Application No: AW/3/21/HH  
Site Address: 4 Shorecroft Aldwick PO21 4AS  
Description of works: Single storey rear extension and loft conversion with enlarged rear dormer window and two modest front facing dormer windows. Alterations to fenestration, Canopy to side elevation, Planter and replacement handrail to roof terrace.

Thank you for your internet representation made on 4th February 2021 which has been recorded as an objection with the comments as follows:

Drawing No. Date:
C.1062H - 04 22-12-20

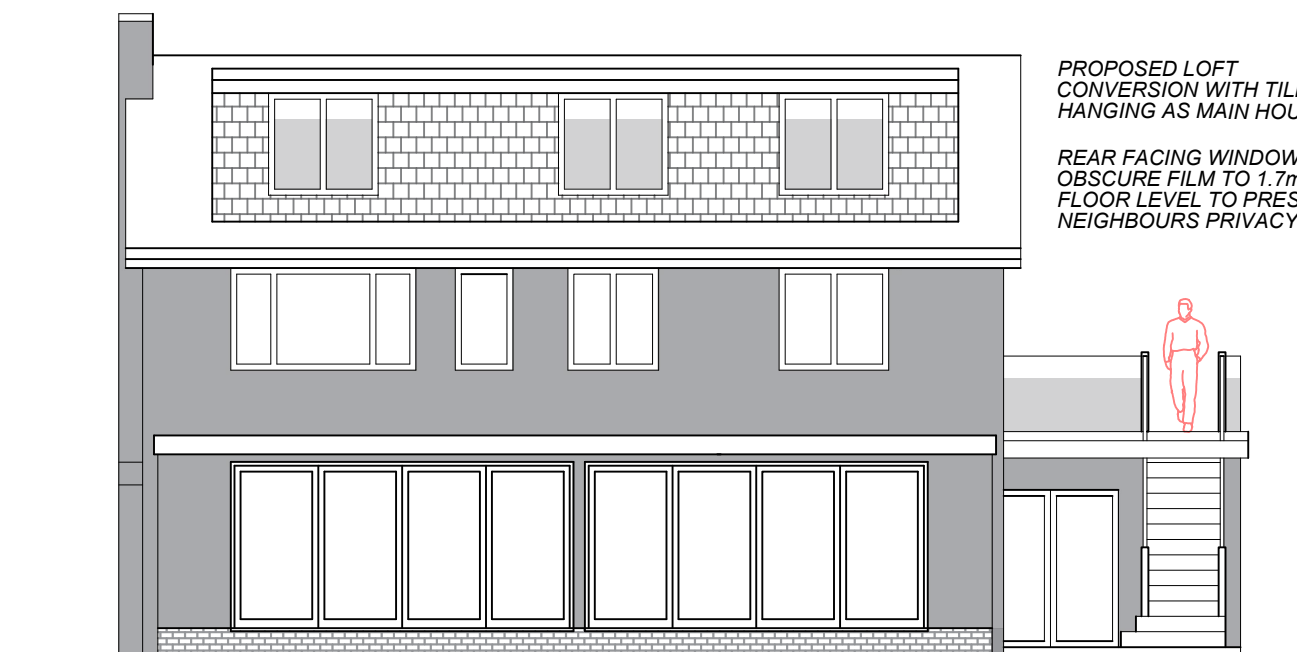
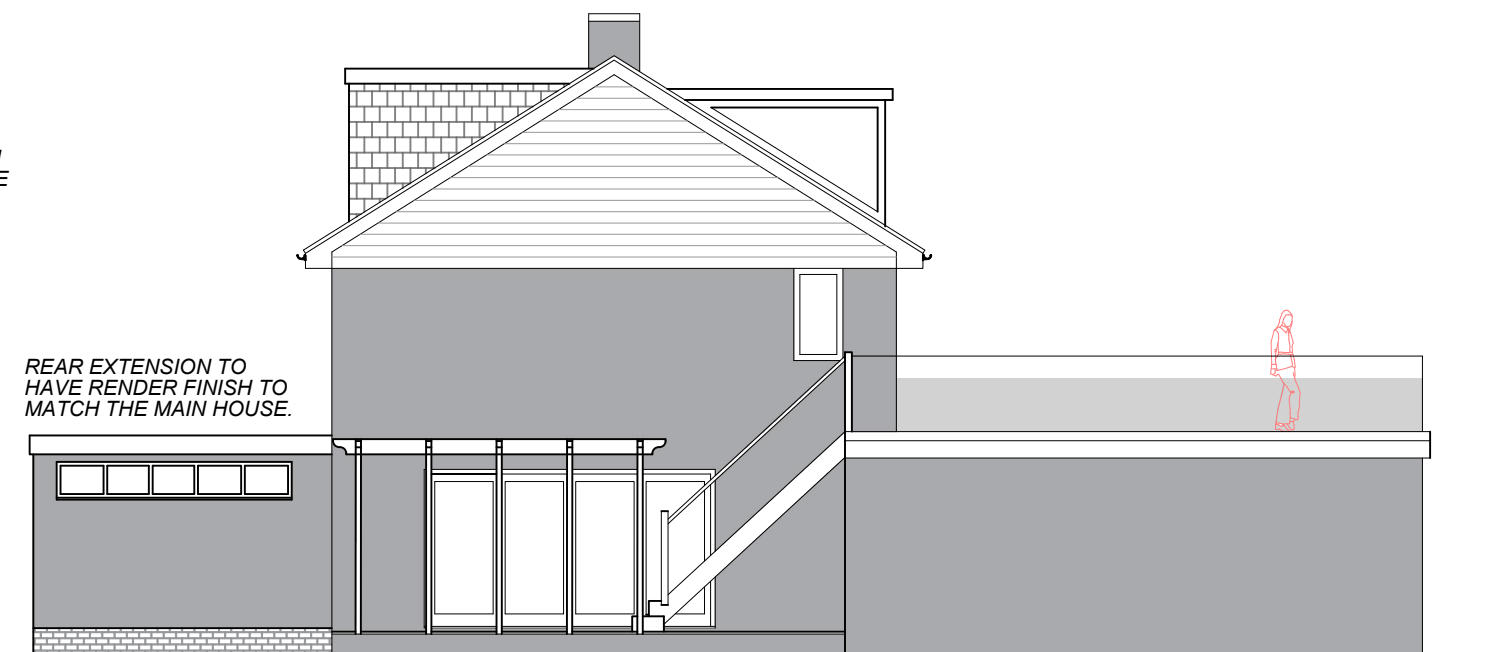
I have no objection to the ground floor development of 4 Shorecroft, however, I do have a very strong objection to the proposed Roof Extension being created by installing an enlarged dormer, to the low pitched roof, to the rear of the property, creating an unsightly, even ugly third floor.

Despite the flowery descriptions of their design used by the submitting Agent, the orientation of the large dormer certainly does not diminish its visual impact. To the contrary, with the proposed addition of two large dormer windows to the front of the property, the visual impact viewed from Wallfield and Hornbeam Close will be devastating and will give the appearance of a box being placed on the second floor. This in no way shape or form can be described as fitting in with the surrounding area, nor in keeping with the Design and Architectural integrity of the Estate.
